East West Rail Phase 2

Stage 2 Road safety audit response report

Offline Highways Passing Places – Package 2 – Oxfordshire (A3 Marsh Gibbon – Compound Access)

Document Number: 133735_RW-EWR-XX-XX-RP-CH-000049

Drawing Title
PASSING PLACE A3_P_10 EXISTING UTILITIES AND SITE CLEARANCE

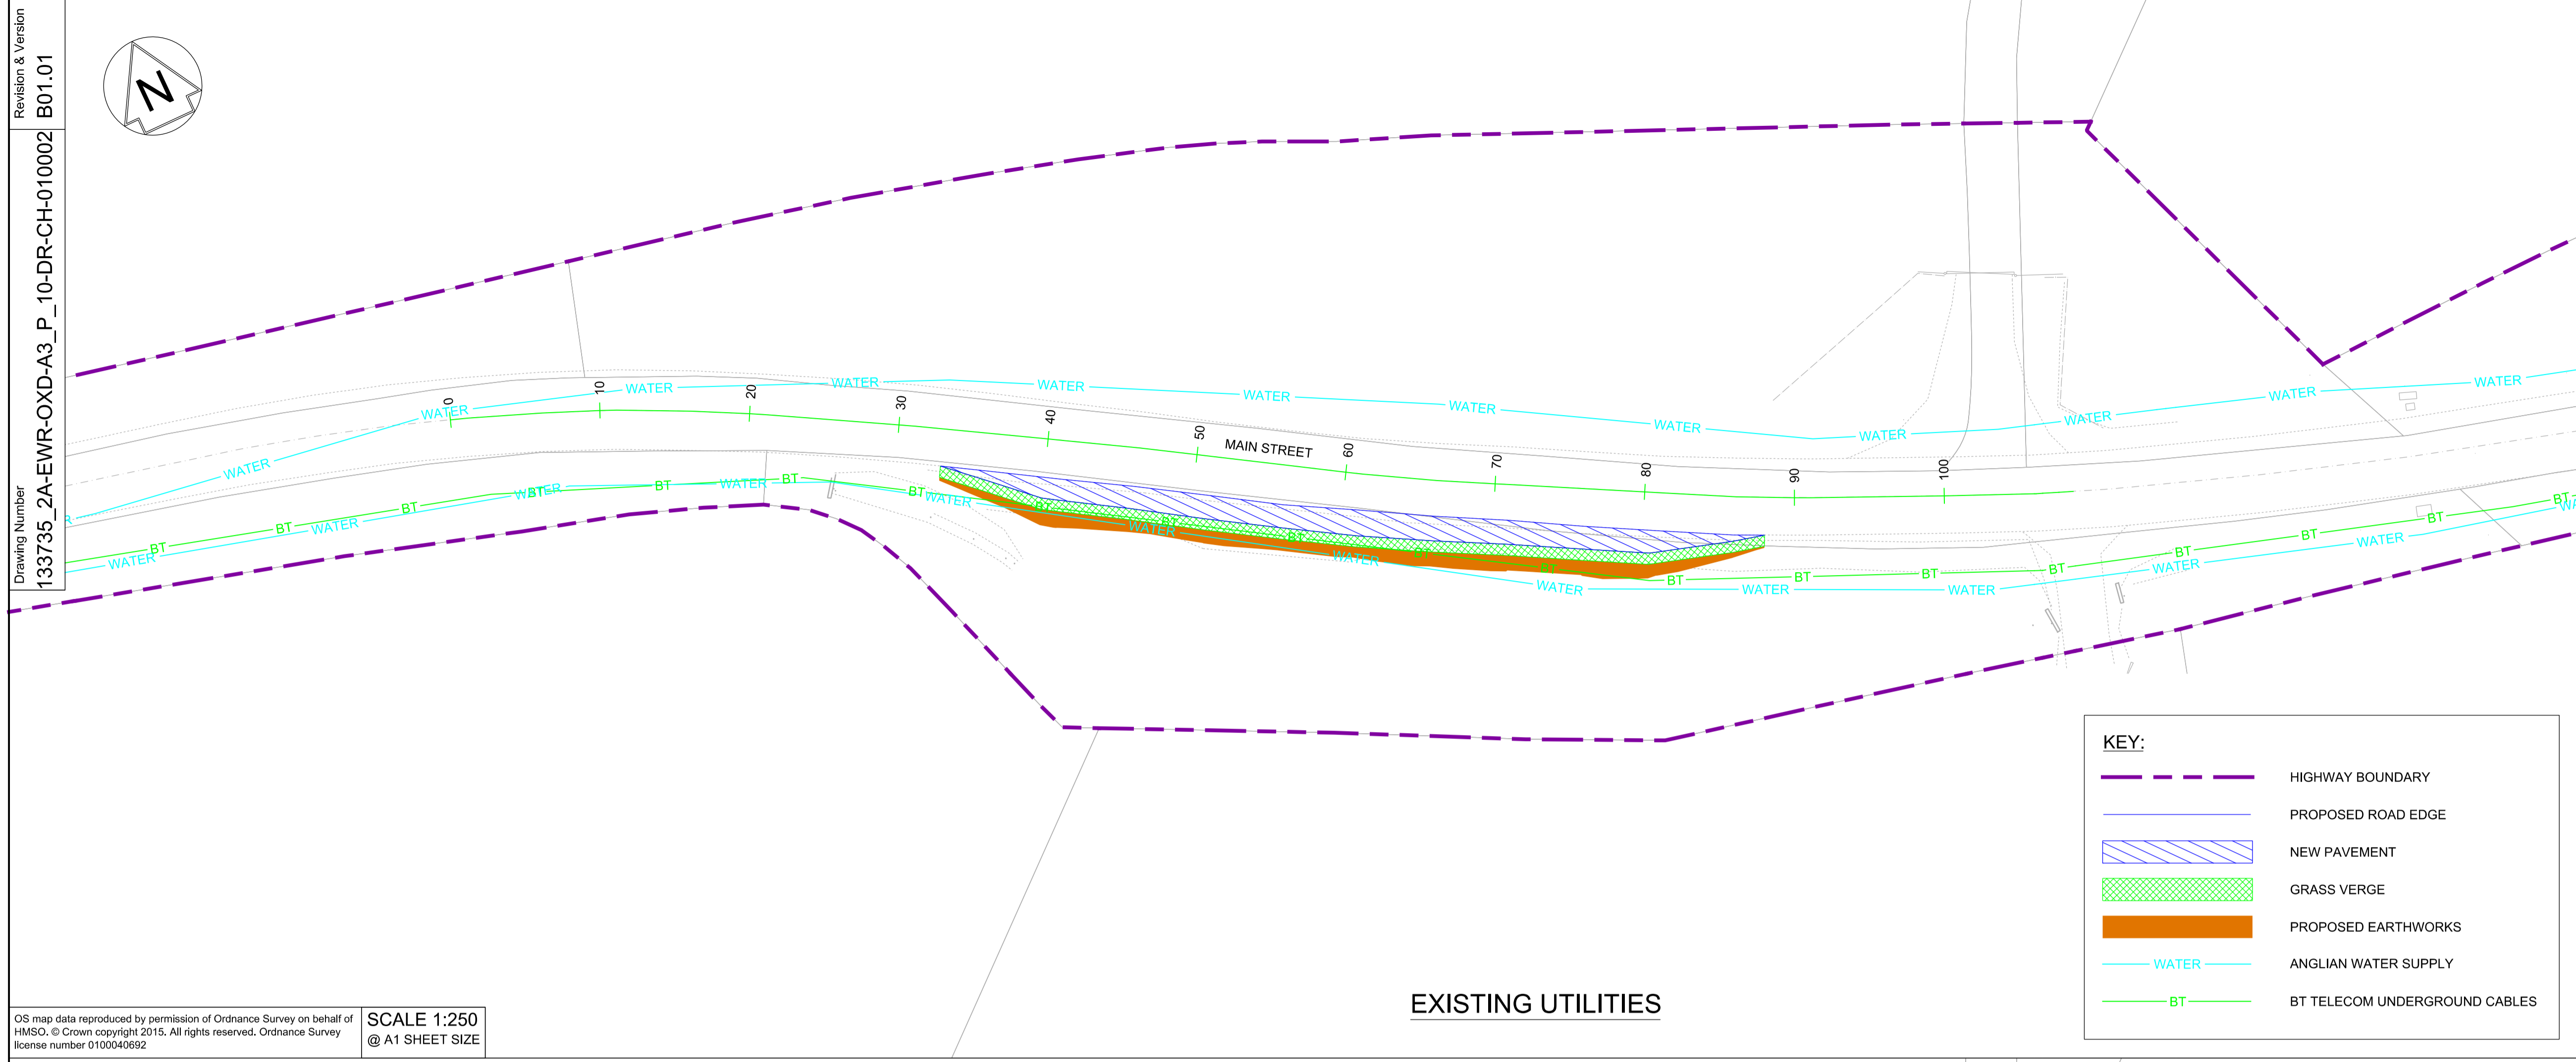
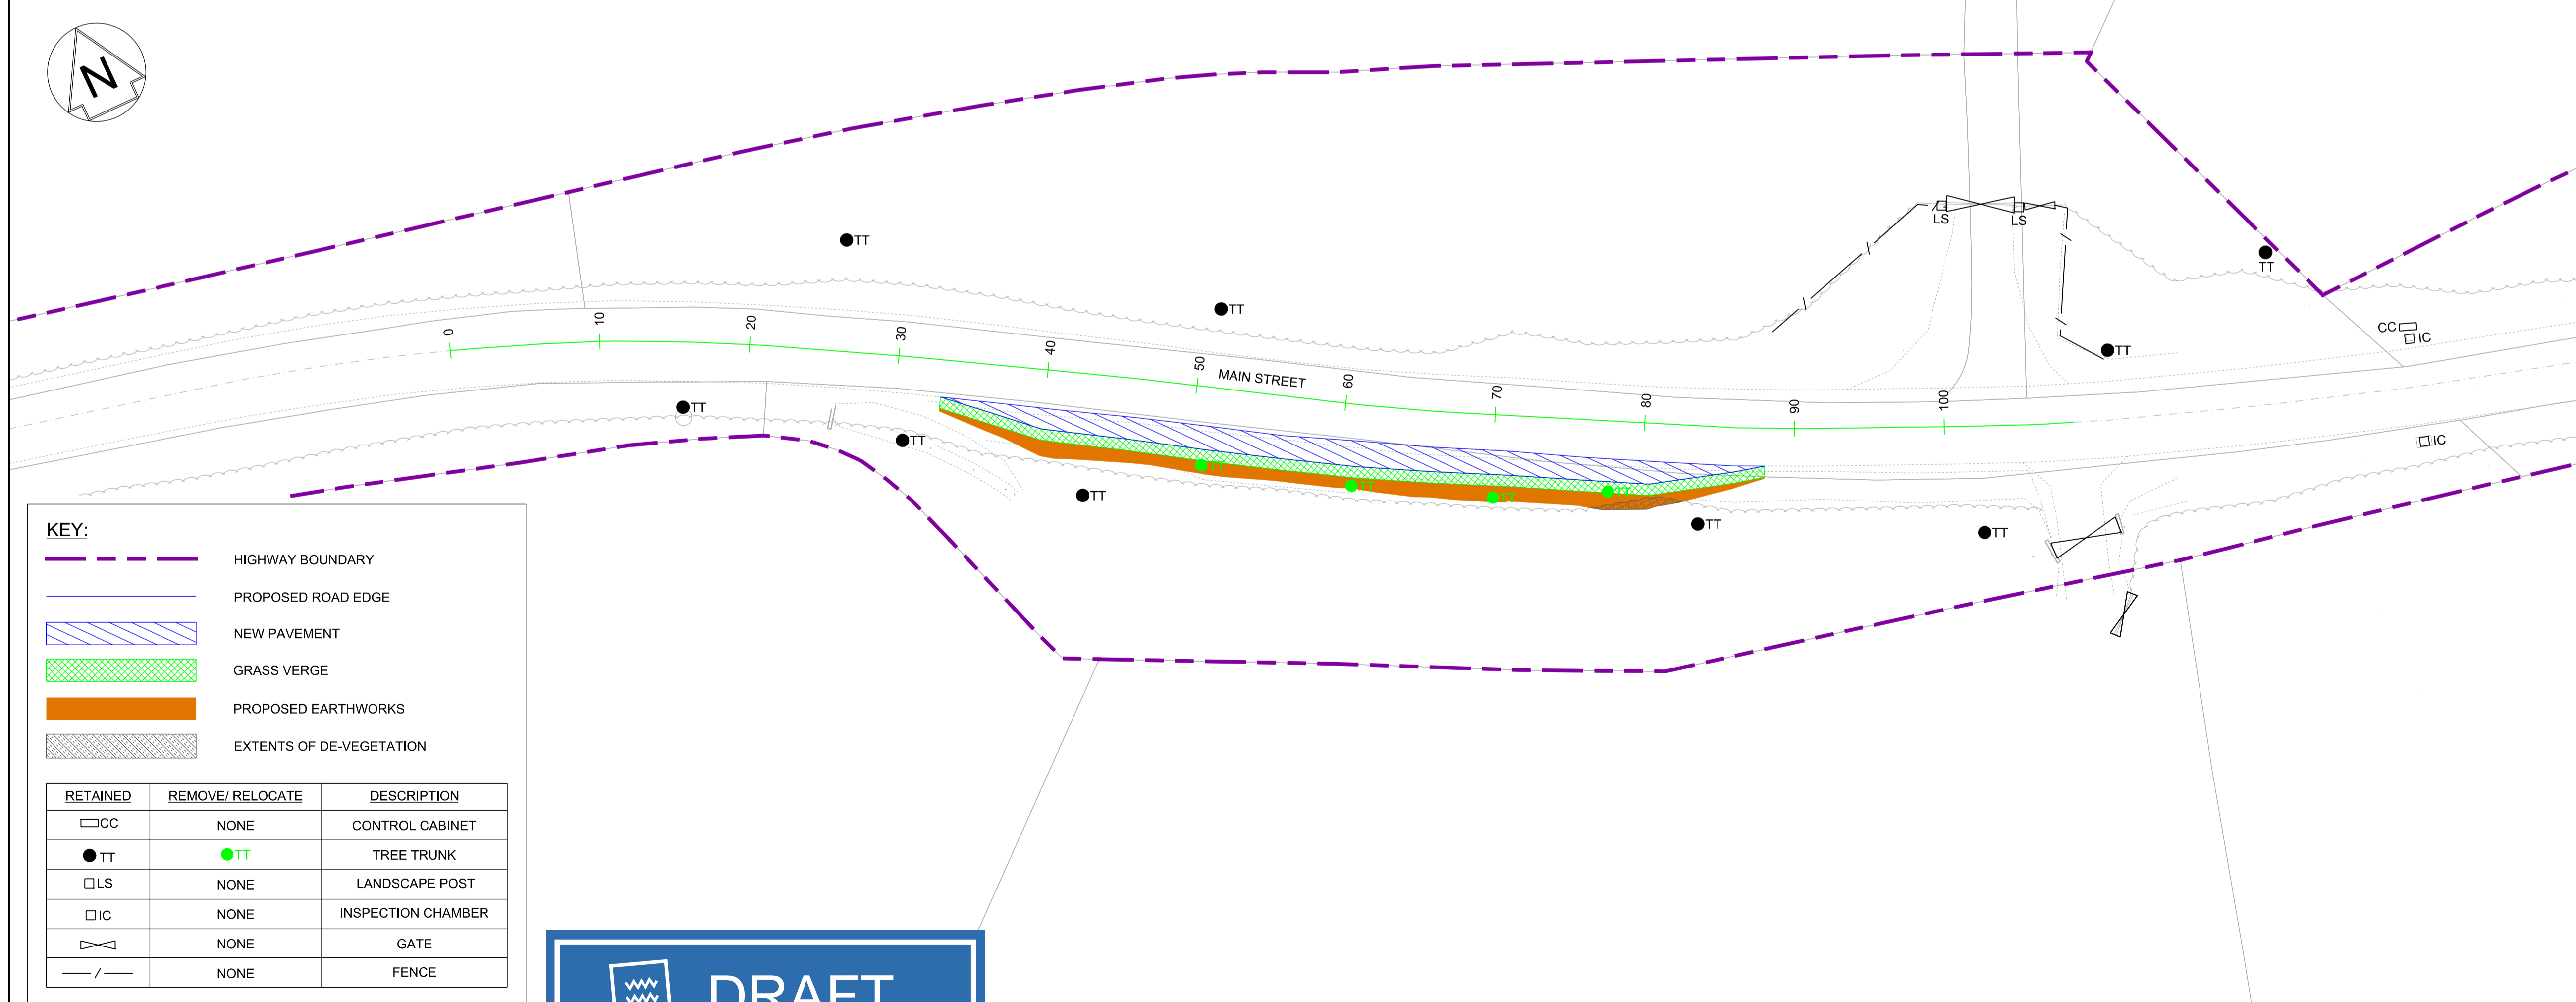
Location: Passing Places A2-P-1, A3-P-2, A3-P-3, A3-P-5, A3-P-7 and A3-P-10. Unnamed Road (towards Mill Road) and Unnamed Road.

Summary: Proximity of passing place to farm traffic access increases risk of collision. There are accesses used by farm traffic along the Unnamed Road (towards Mill Road). As a farm vehicle enters or exits these accesses from Unnamed Road (towards Mill Road), there is a likelihood that a construction vehicle may collide with it as they may not anticipate the turning farm vehicle, particularly when they are preparing to enter the passing place. This issue is exacerbated by the presence of vegetation around these accesses which reduces the visibility between farm traffic and construction drivers using the Unnamed Road (towards Mill Road).

RECOMMENDATION

Provide traffic signing to warn of construction passing places and farm traffic accesses. Trim back vegetation around the accesses to maximise intervisibility.

RSA Ref	Location	RSA Problem	RSA Recommendation	Design Team Response	Network Rail Response	Agreed RSA action
2.4	<p>Passing Places A2-P-1, A3-P-2, A3-P-3, A3-P-5, A3-P-7 and A3-P-10. Unnamed Road (towards Mill Road) and Unnamed Road.</p>	<p>Proximity of passing place to farm traffic access increases risk of collision There are accesses used by farm traffic along the Unnamed Road (towards Mill Road). As a farm vehicle enters or exits these accesses from Unnamed Road (towards Mill Road), there is a likelihood that a construction vehicle may collide with it as they may not anticipate the turning farm vehicle, particularly when they are preparing to enter the passing place. This issue is exacerbated by the presence of vegetation around these accesses which reduces the visibility between farm traffic and construction drivers using the Unnamed Road (towards Mill Road).</p>	<p>Provide traffic signing to warn of construction passing places and farm traffic accesses. Trim back vegetation around the accesses to maximise intervisibility</p>	<p>Accept the RSA problem and recommendation made by the RSA team. The design includes a signage strategy which provides signs to notify drivers that the road has passing places. The site clearance drawings include vegetation clearance to achieve required visibility and signage strategy drawings likewise include this provision.</p>	Accepted	Proceed as Design Team Response
